RJC:15-166

Re: SSD 7693 – Intercontinental Hotel
Response to request for additional information

Thank you for your email of 27 August 2018 (4.21 pm) in relation to the SSD application for the Intercontinental Hotel and Transport House.

SETBACK DIAGRAM | VIEW FROM NORTH-EAST

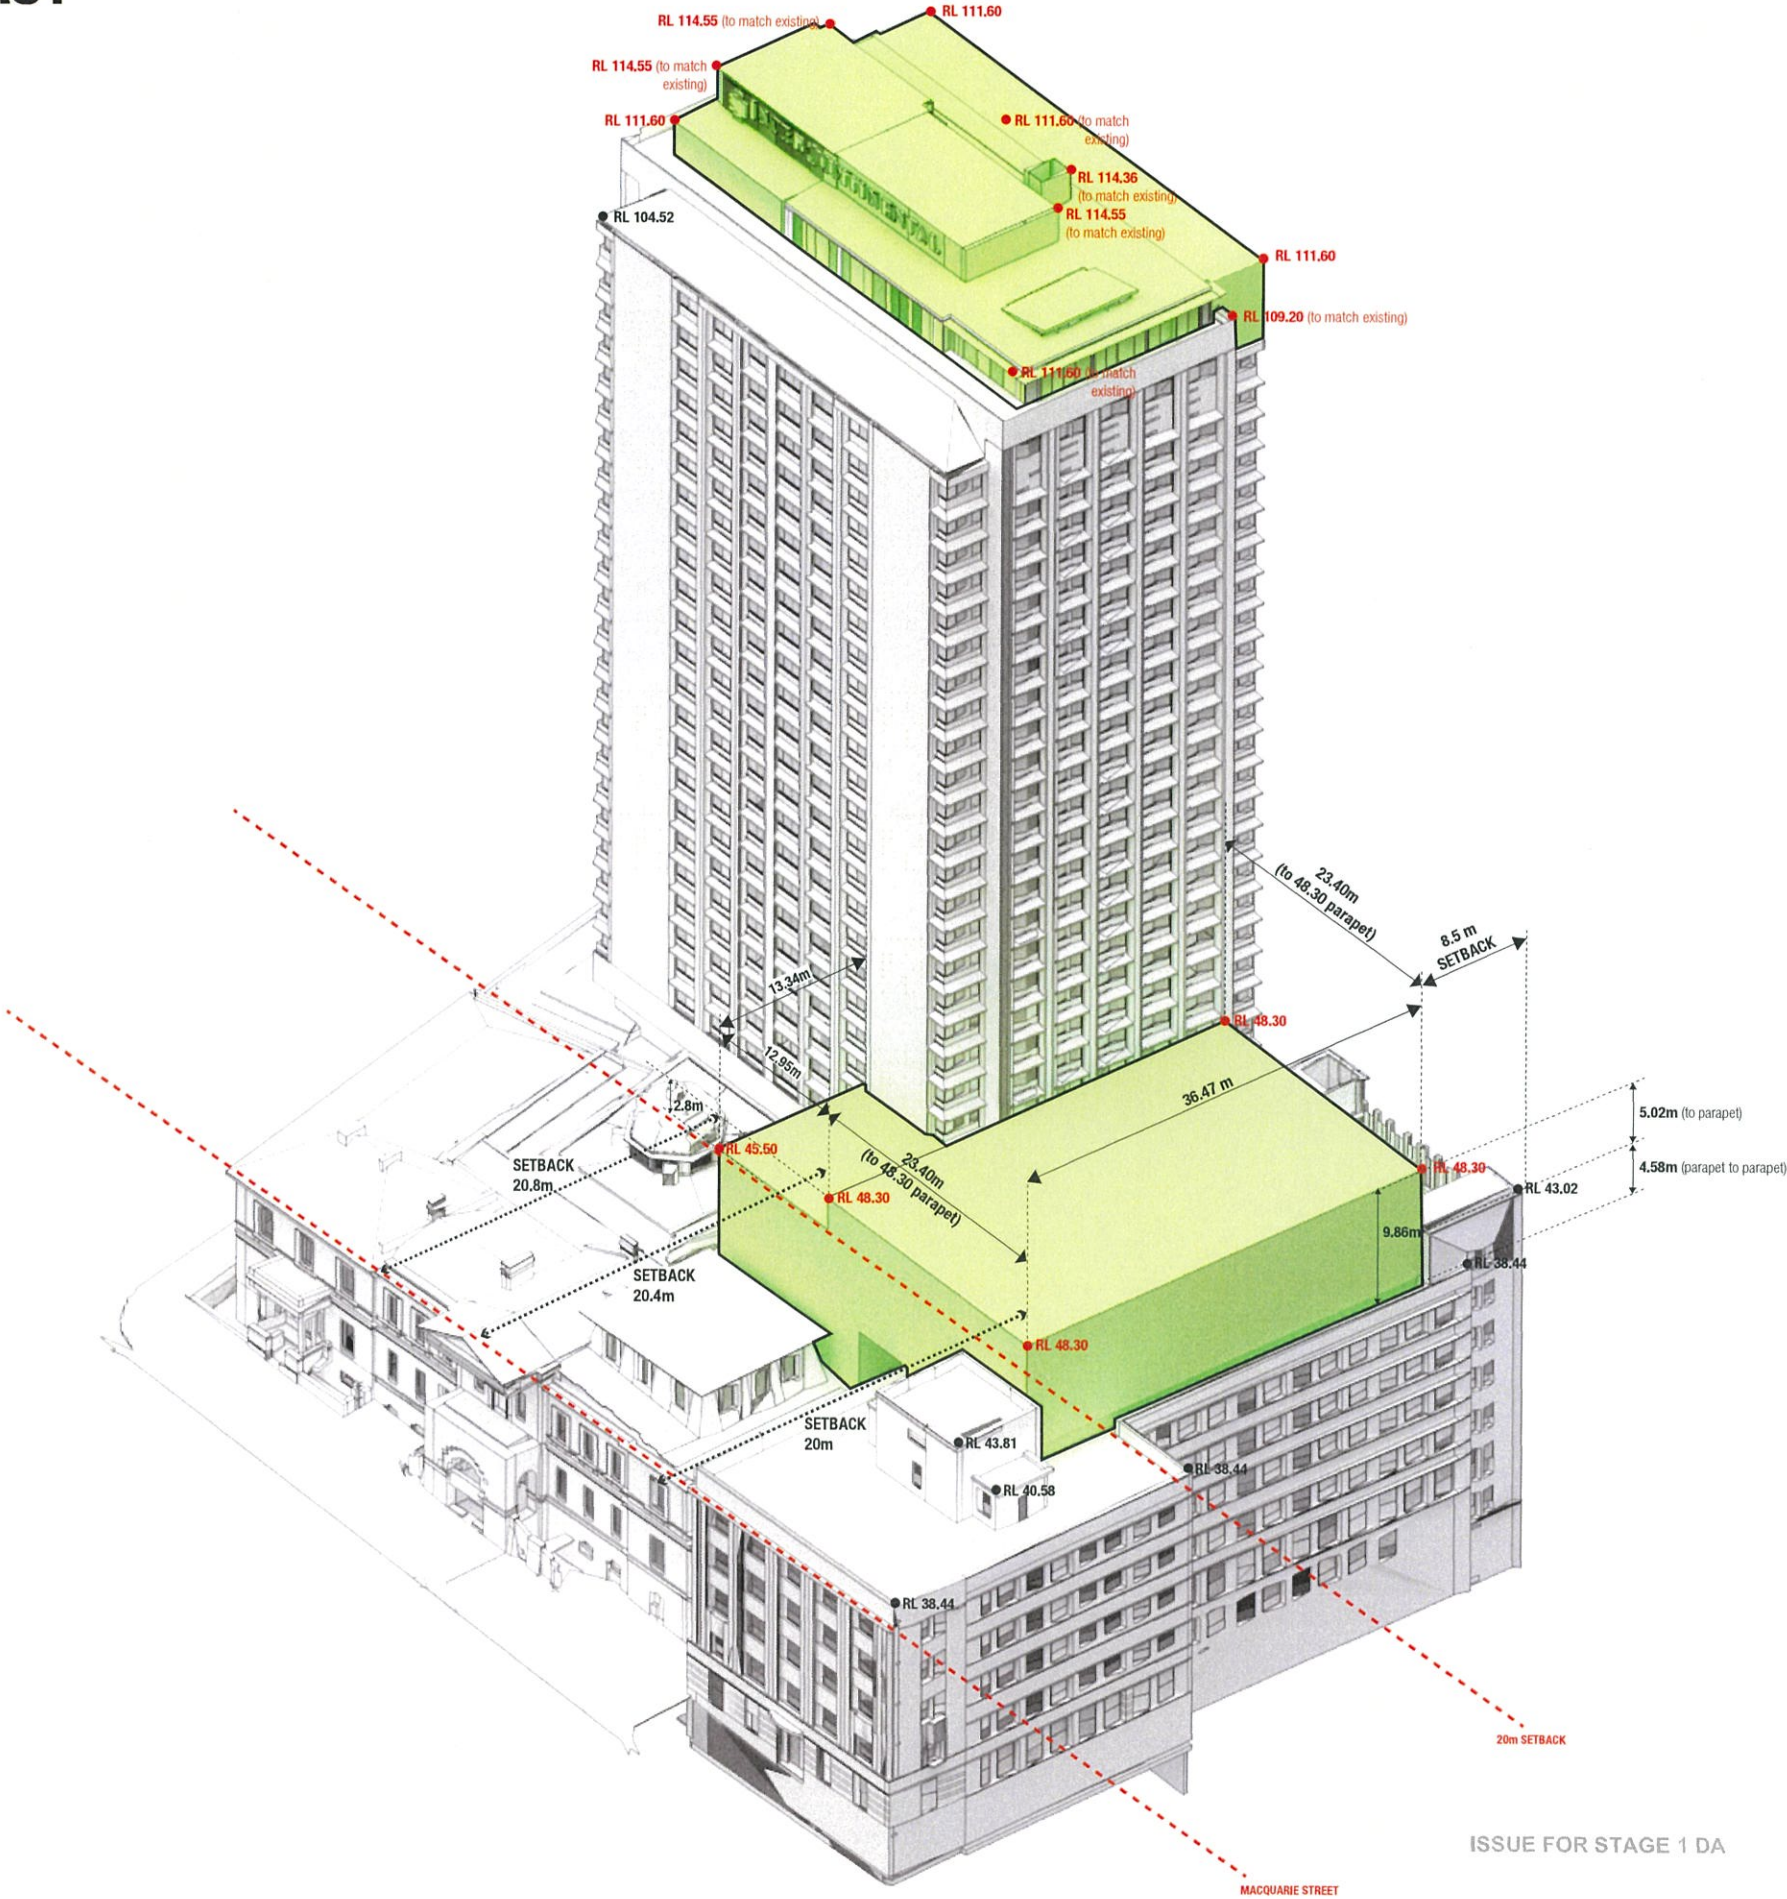
- (b) the setback diagram showing the proposed building envelope from the north-east and south west in the RtS should be dated and include a reference numbers. The north-east diagram should include an RL at the roof of Transport House and the Strong*

Room/hotel podium and also dimensions showing the height of the proposed building envelope.

The requested revised setback diagram (Site Plan ST1-DA_001) showing the required details, is provided in **Attachment 1B**.
